**KIRKLEES METROPOLITAN COUNCIL  
INVESTMENT & REGENERATION SERVICE**

Reference No:	<b>2024/62/92935/E</b>
Site Address:	33, Union Street, Dewsbury, WF13 1AS
Description:	Change of use and alterations to shops to form 4 apartments (within a Conservation Area)
Recommending Officer:	Nicole Helliwell

## **Officer Report**

**Proposal:** Change of use and alterations to shops to form 4 apartments (within a Conservation Area).

PROPOSED FRONT ELEVATION

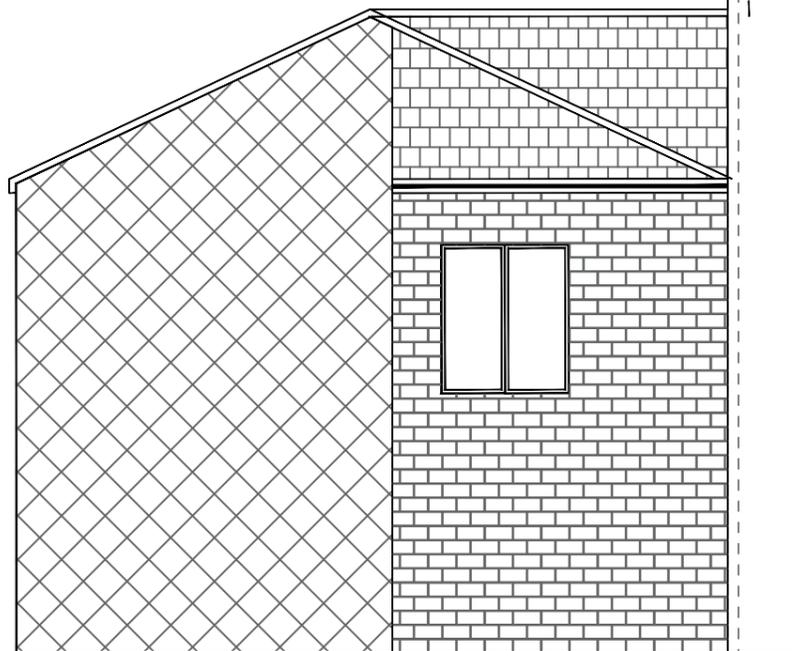
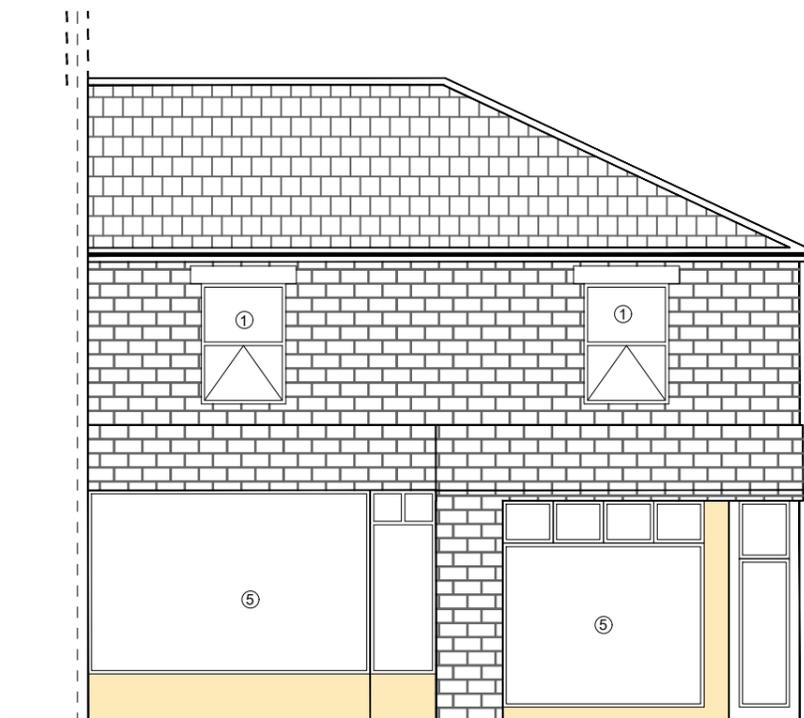
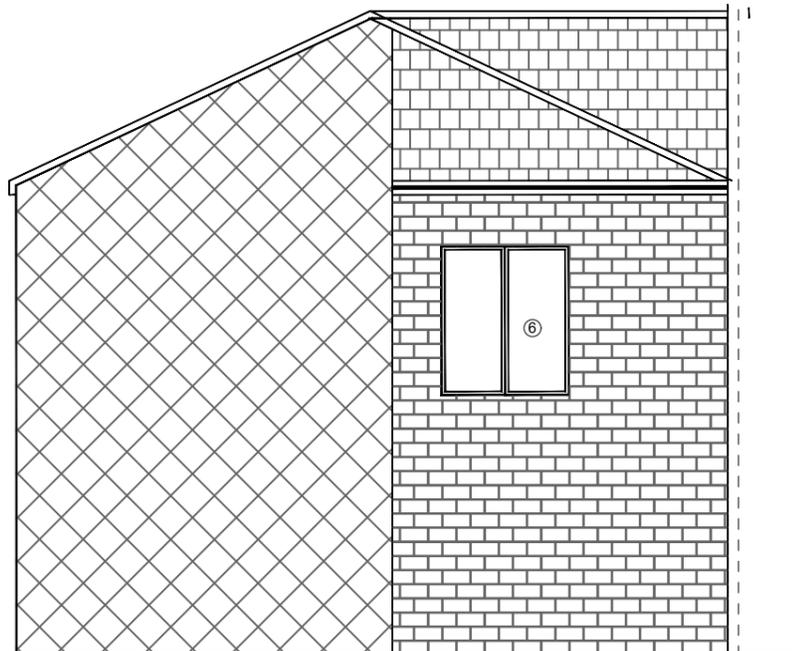
It is noted that minor external alterations are proposed as part of the application. The submitted plans confirm that the existing shop fronts within

the front and side elevations of the building would be blocked up and replaced with new windows and openings to serve the flats. Furthermore, the existing first floor fenestration within the front elevation of the building would be blocked up and replaced with four windows. Given the small scale of the proposed alterations, it is considered that they would have no significant visual impacts on the character and appearance of the street scene.

Officers noted that the shop front would be lost as part of the application which would

It was considered that the external alterations proposed would materially detract from the character and appearance of this period property, the setting of Dewsbury Town Centre Conservation Area and 18, 20 and 22 Bond Street, Grade II listed buildings. There are no public benefits to outweigh the less than substantial harm to the setting and character of the adjacent Listed Buildings and the Dewsbury Town Centre Conservation Area. To permit the

1. The external alterations proposed would materially detract from the character and appearance of the Dewsbury Town Centre Conservation Area and 18, 20 and 22 Bond Street, Grade II listed buildings. There are no public
